REQUEST

Current Zoning: N1-A (neighborhood 1-A)
Proposed Zoning: N1-F(CD) (neighborhood 1-F, conditional)

The petition proposes to develop two triplex buildings and one quadplex on two parcels currently developed with two single family detached homes.

**RZ-1**

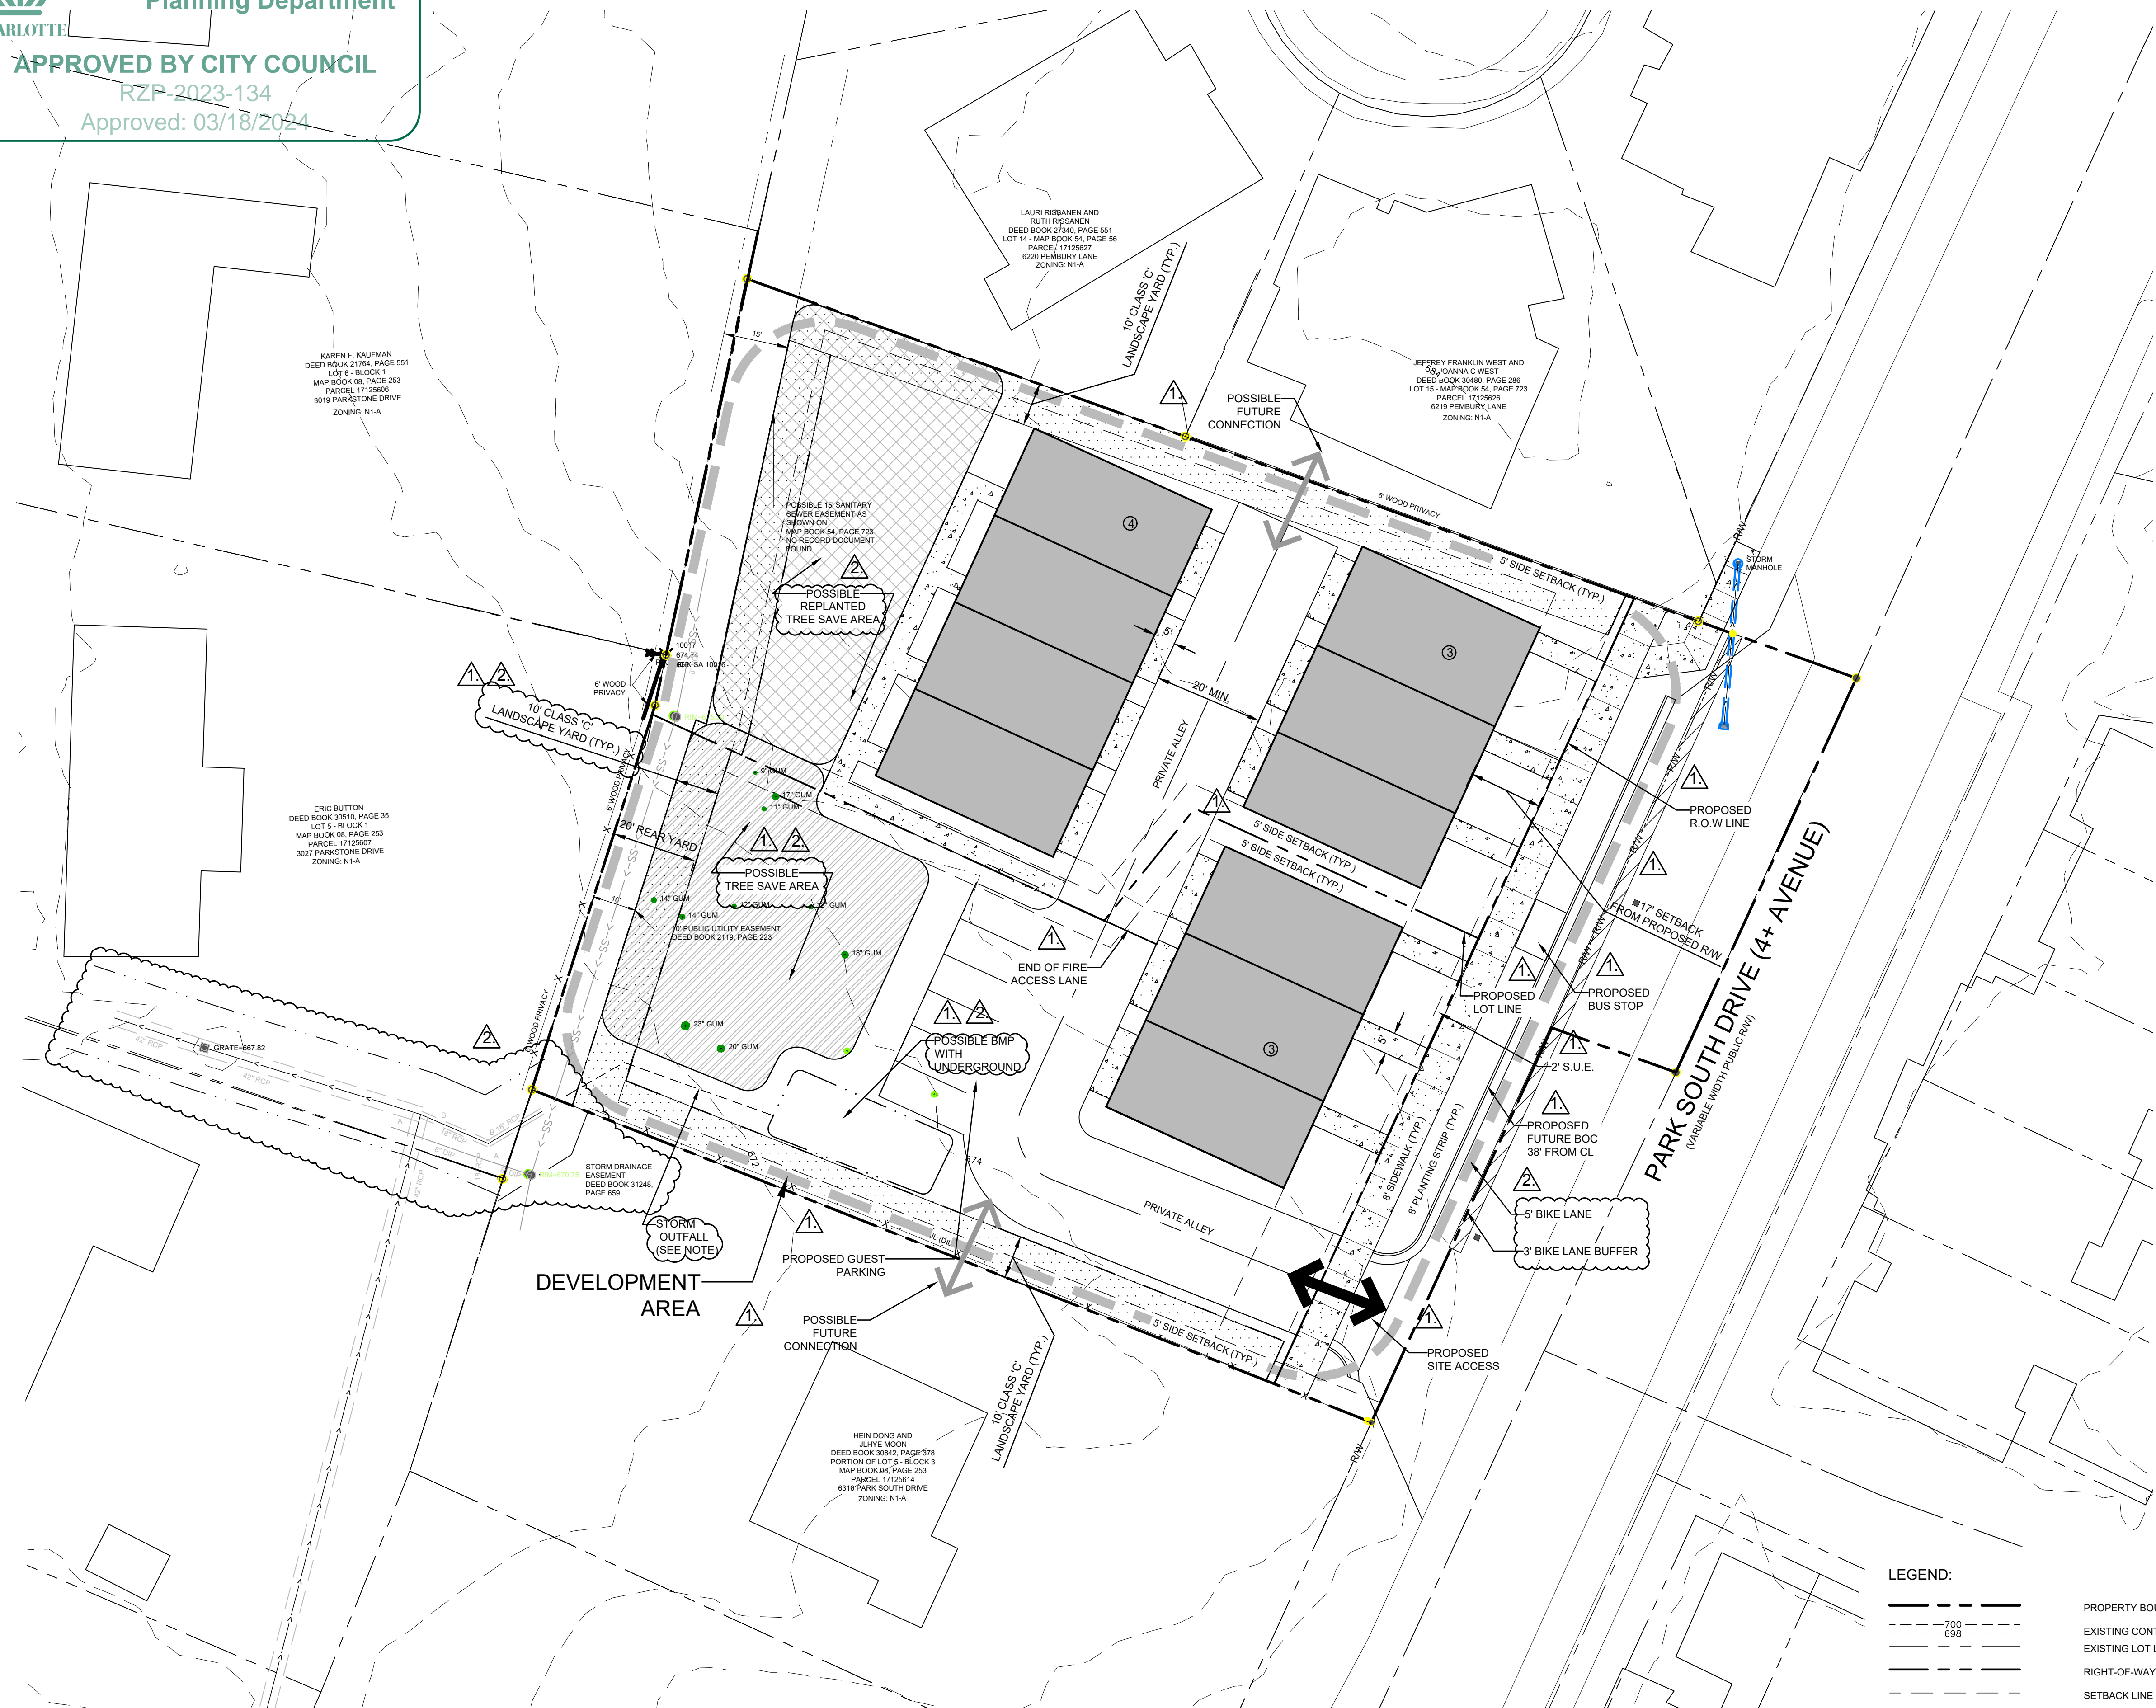
1. ~~Revise the proposed driveways for the individual units to be compliant with Article 19.6.A.1.a of the UDO.~~ **Addressed**

2. ~~Clarify if the tree save area shown on the site plan is outside of the demolition plan.~~ **Addressed**
3. ~~The replanted tree save area will have to be at a higher rate than the required minimum of 15% of the site. Increase the proposed tree save on the plan.~~ **Addressed**

4. ~~The dimension for the proposed back of curb to the center line must be shown on the site plan as well as the buffered bike lane that is required per the Charlotte Streets Map cross section.~~ **Addressed**
